MORGAN AND MORECAMBE OFFSHORE WIND FARMS: TRANSMISSION ASSETS

Works Plans - Onshore and Intertidal – Part 1 of 2

Document reference: B8/F04
Rev: F04

02 October 2025

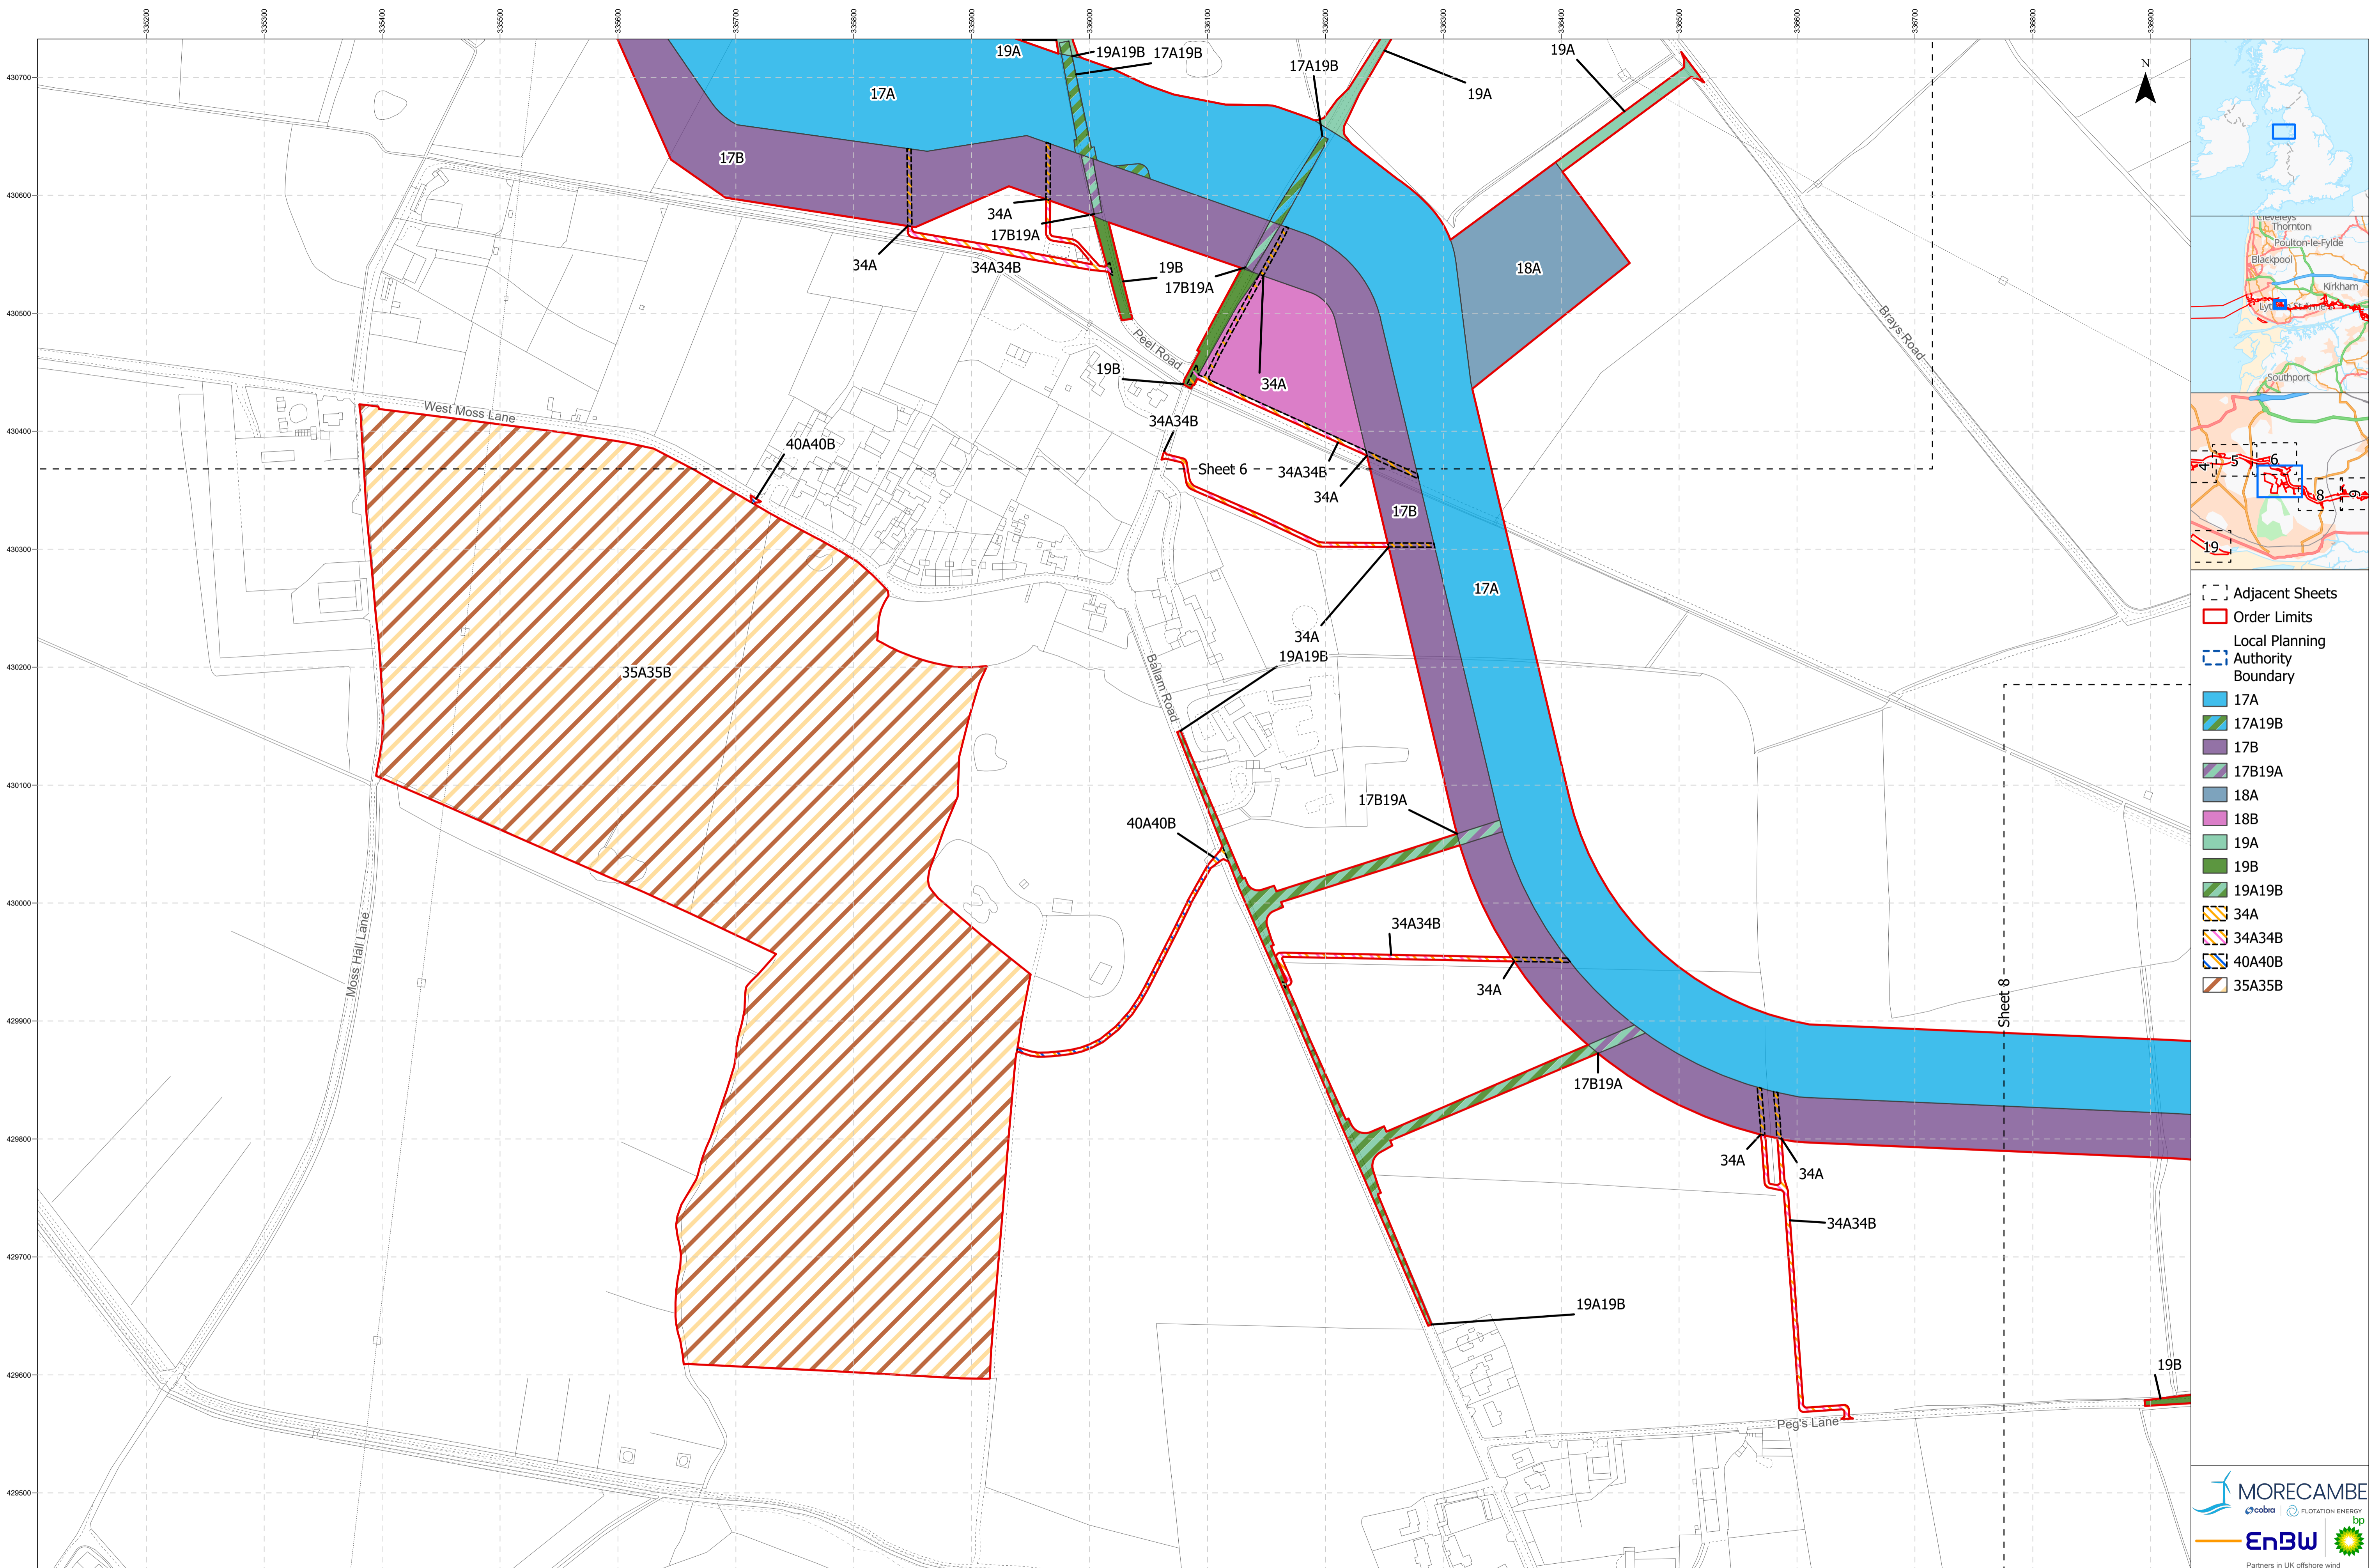
Sheet Number	Change requested by	Change Made	Reason for Change	Revision	Submission deadline
5	The Applicants	Permanent access (Work No. 34A) has been extended, near to Moss Sluice watercourse.	A review of the works plans identified that permanent access (Work No. 34A) to Morgan's onshore export cable corridor (Work No. 17A) was previously omitted. This has now been updated to reflect the Morgan permanent access (Work No. 34A) to cable corridor (Work No. 17A)	F02	S51 advice update
5	The Applicants	The permanent access (Work No. 34A34B) to both Morecambe and Morgan's onshore cable works (Work No. 17A and 17B) has been refined west of Midgeland Road.	A review of the works plans identified that permanent access (Work No. 34A) did not need to extend over Morgan's onshore export cable corridor (Work No. 17A). Similarly, permanent access (Work No. 34B) did not need to extend over Morecambe's onshore export cable corridor (Work No. 17B).	F02	S51 advice update

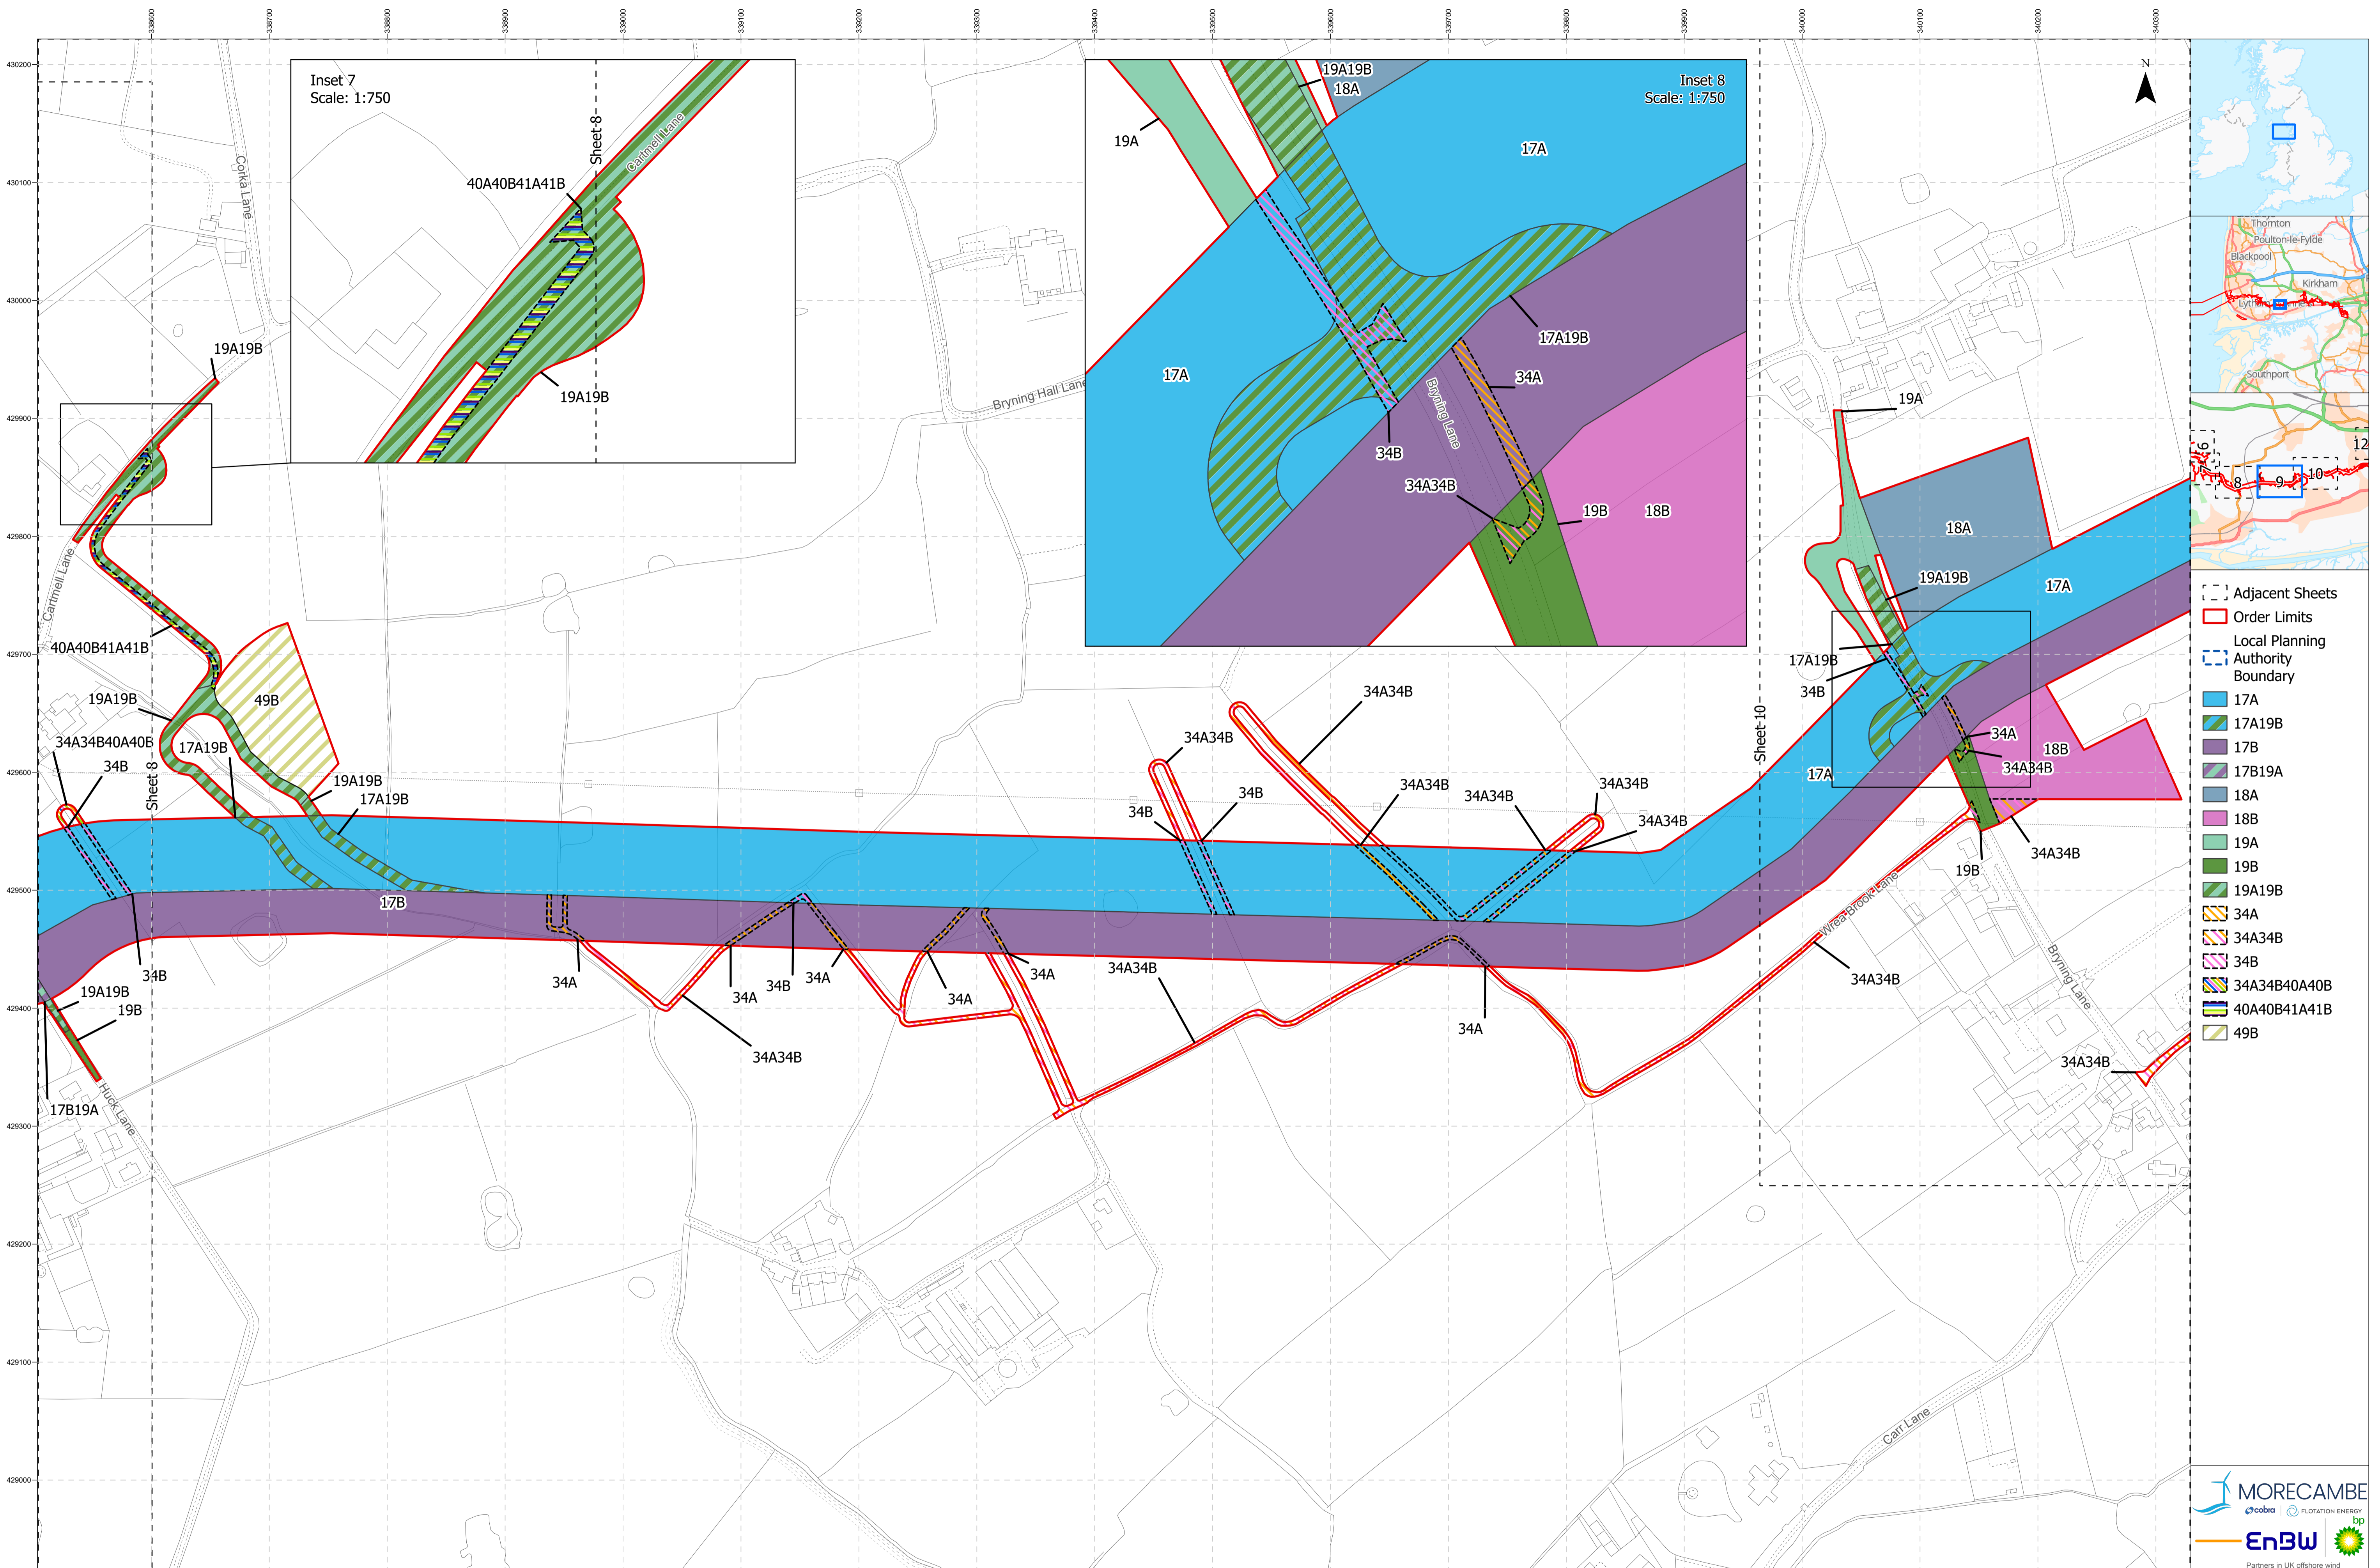
8	The Applicants	Construction access to environmental mitigation works (Work No. 40A40B) has been removed, south of Cartmell Lane.	A review of the works plans identified that construction access to environmental mitigation works (Work No. 40A40B) was not required at this location.	F02	S51 advice update
9	The Applicants	Morgan construction and permanent access to environmental mitigation works (Work No. 40A41A) has been remove off Cartmell Lane.	A review of the works plans identified that construction and permanent access to environmental mitigation works (Work No. 40A41A) was not required at this location.	F02	S51 advice update
9	The Applicants	Permanent access (Work No. 34A34B) off Wrea Brook Lane has been removed.	A review of the works plans identified that permanent access (Work No. 34A34B) was not required at this location.	F02	S51 advice update
